Our Reference: **SHARE/ 80693510**
Your Reference: West Midlands Interchange

WEST MIDLANDS INTERCHANGE DCO – REQUEST FOR COMMENTS FROM SECRETARY OF STATE

We note the request for comments from the Secretary of State regarding the application by Four Ashes Limited for the West Midlands Interchange Development Consent Order within a letter dated 24th January 2020. Highways England's response is set out below.

## **Transport Technical Note 46 – A449 / A5 Link Road Signalised Crossing**

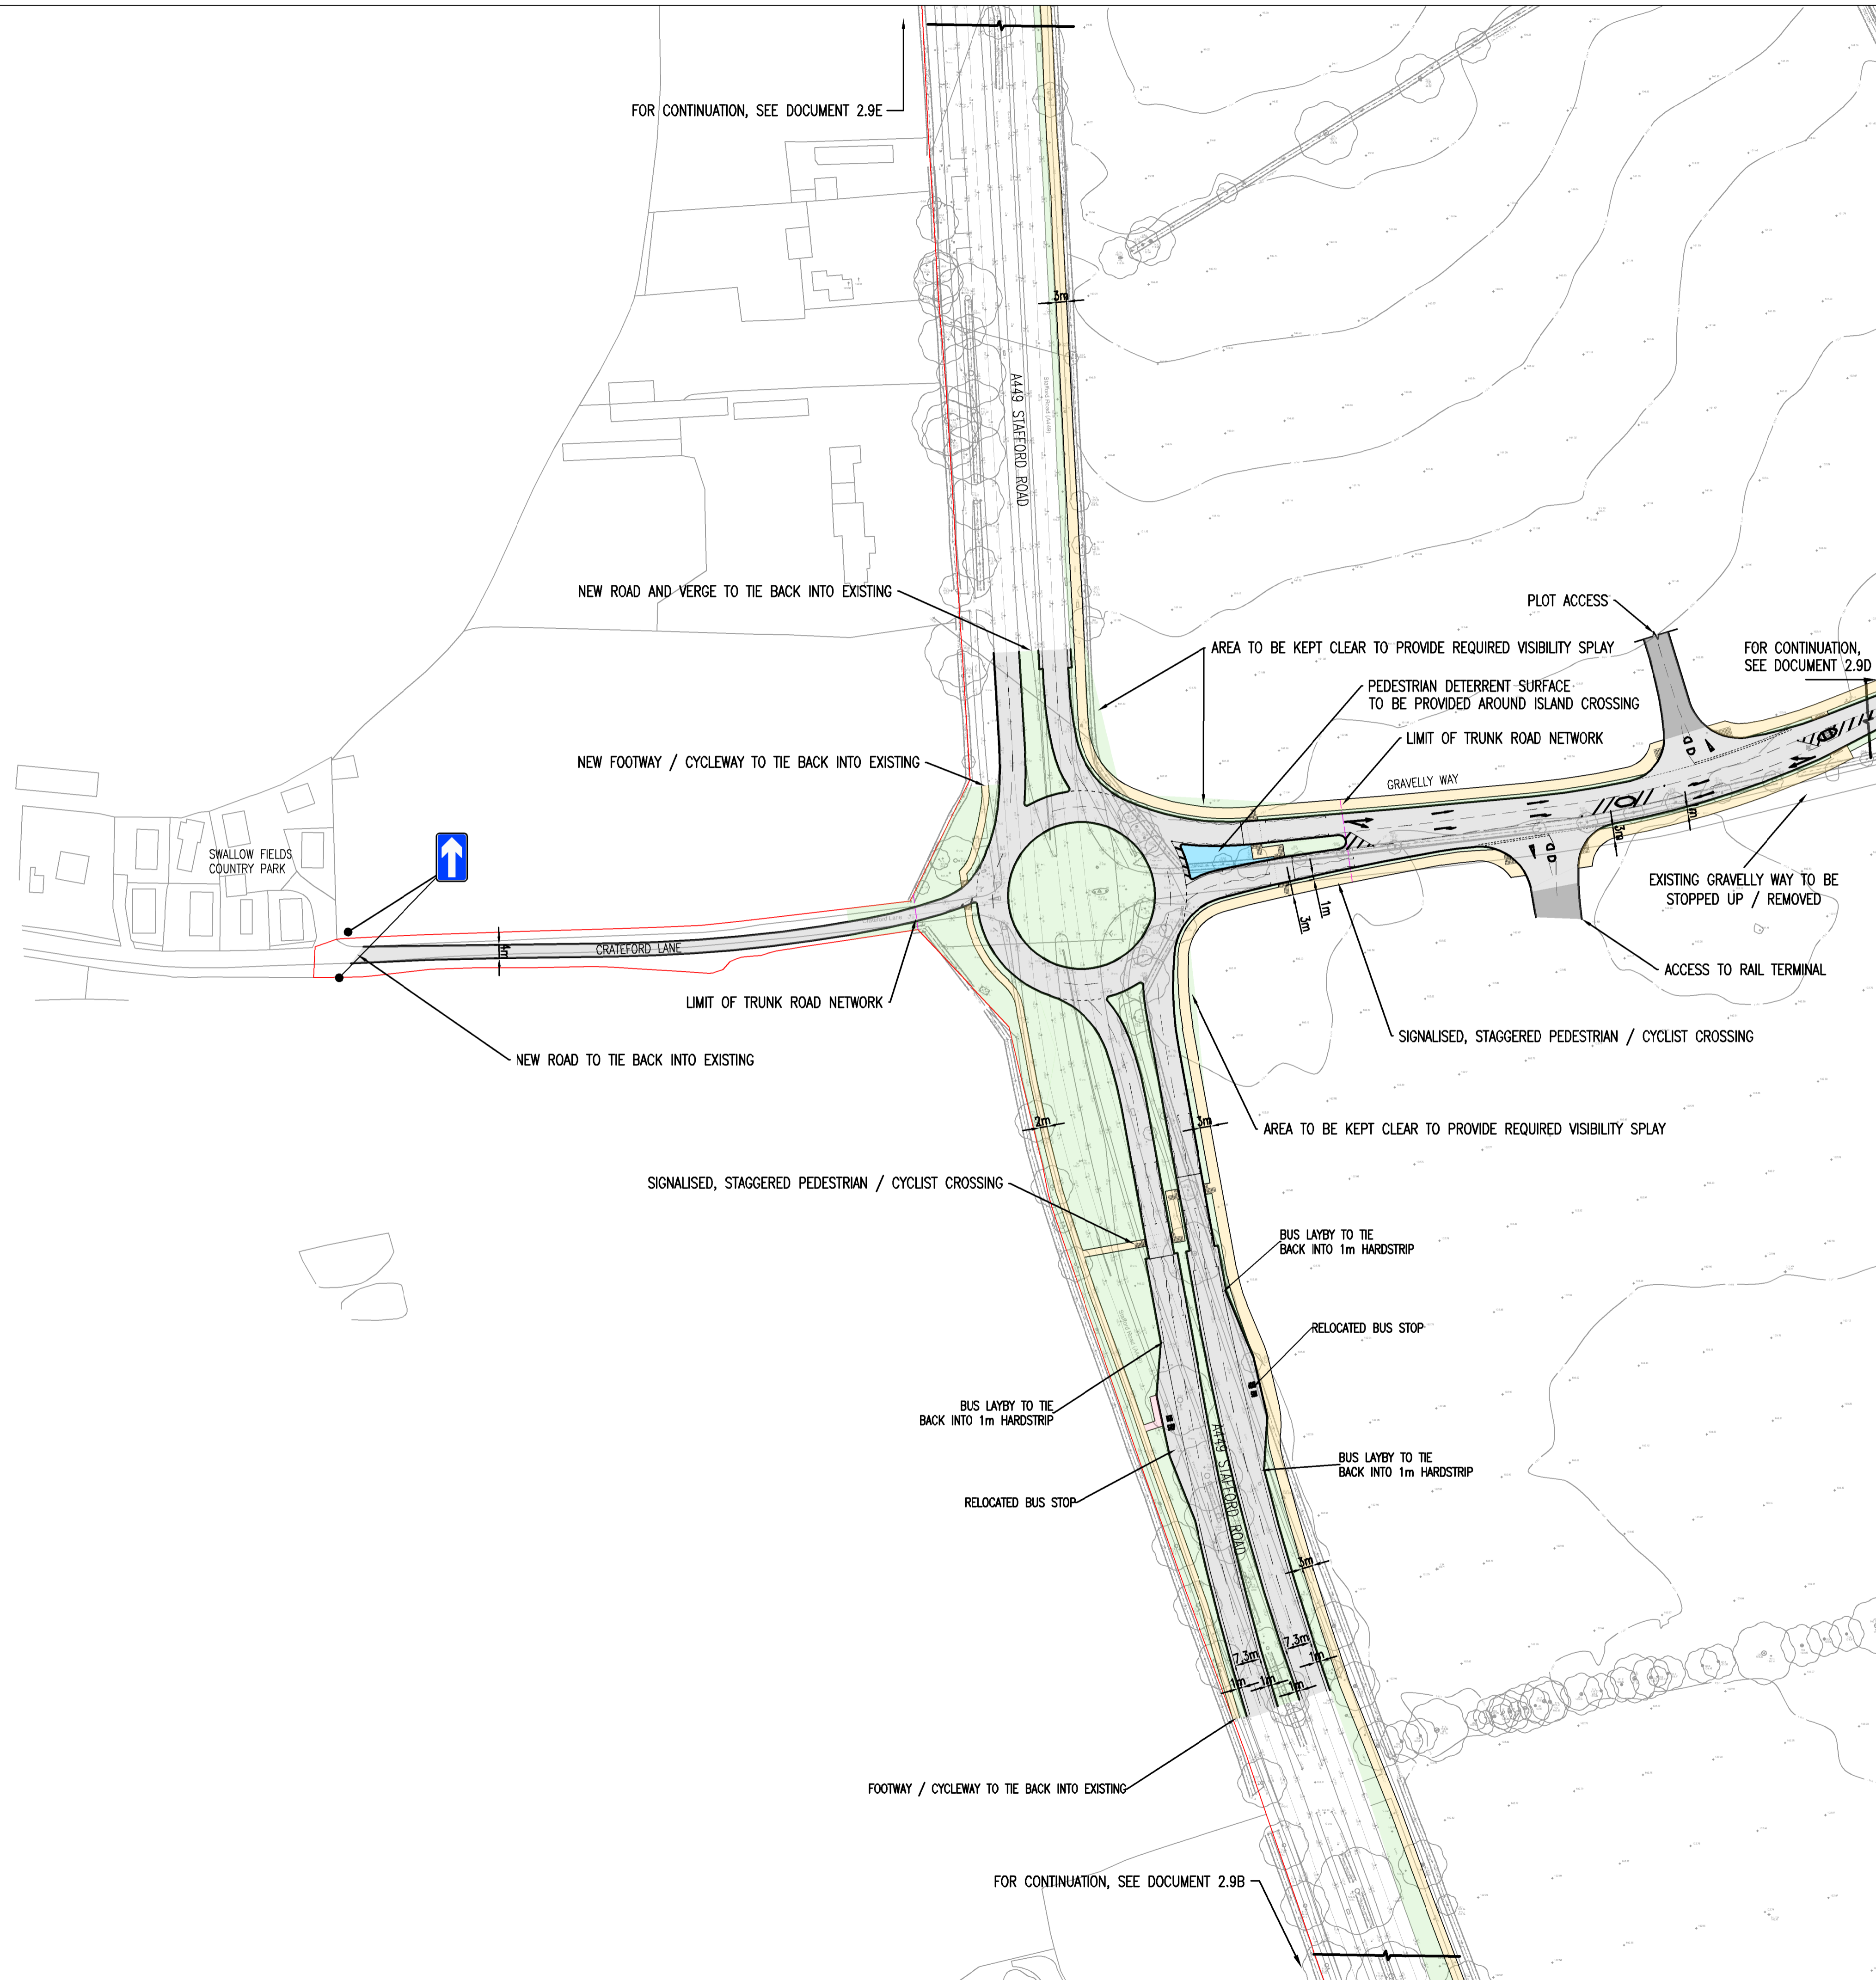
Further design discussions led to a revised Toucan crossing being proposed, located closer (approximately 20 metres) to the junction on the A449. The subsequent RSA (August 2019) concluded this had resolved the NMU 'desire line' problem, however raised concerns with visibility on the approach to the crossing from the junction and the potential for blocking back onto the A449 trunk road.

The latest submission is shown on WSP drawing no 70001979-SK-115 rev B dated February 2020 and explained in the revised WSP Technical Note no 46 dated 6 February 2020. This seeks to demonstrate that approach visibility can be achieved and blocking back can be mitigated with the use of 'Keep Clear' markings. In principle, the latest solution appears to address the outstanding RSA issues. Accordingly, we are of the view that there is likely to be a design solution that will resolve our concerns.

We are supportive of this matter being added to the list of details to be submitted and approved. However, we are concerned at only having the role of a consultee on this matter which has direct implications for the Highways England asset. We request that this addition to the list of details to be submitted and approved be updated to refer to not just 'consultation' with Highways England but also ensuring Highways England provides its 'approval' (as set out below with the additional text coloured blue). This amendment is required for the proposed additional wording to be acceptable to Highways England.

“the location of the pedestrian crossing on the A5/A449 link road notwithstanding the detail shown in that respect on the Highway plans (in consultation with the local highway authority and [with the approval](#) Highways England)”
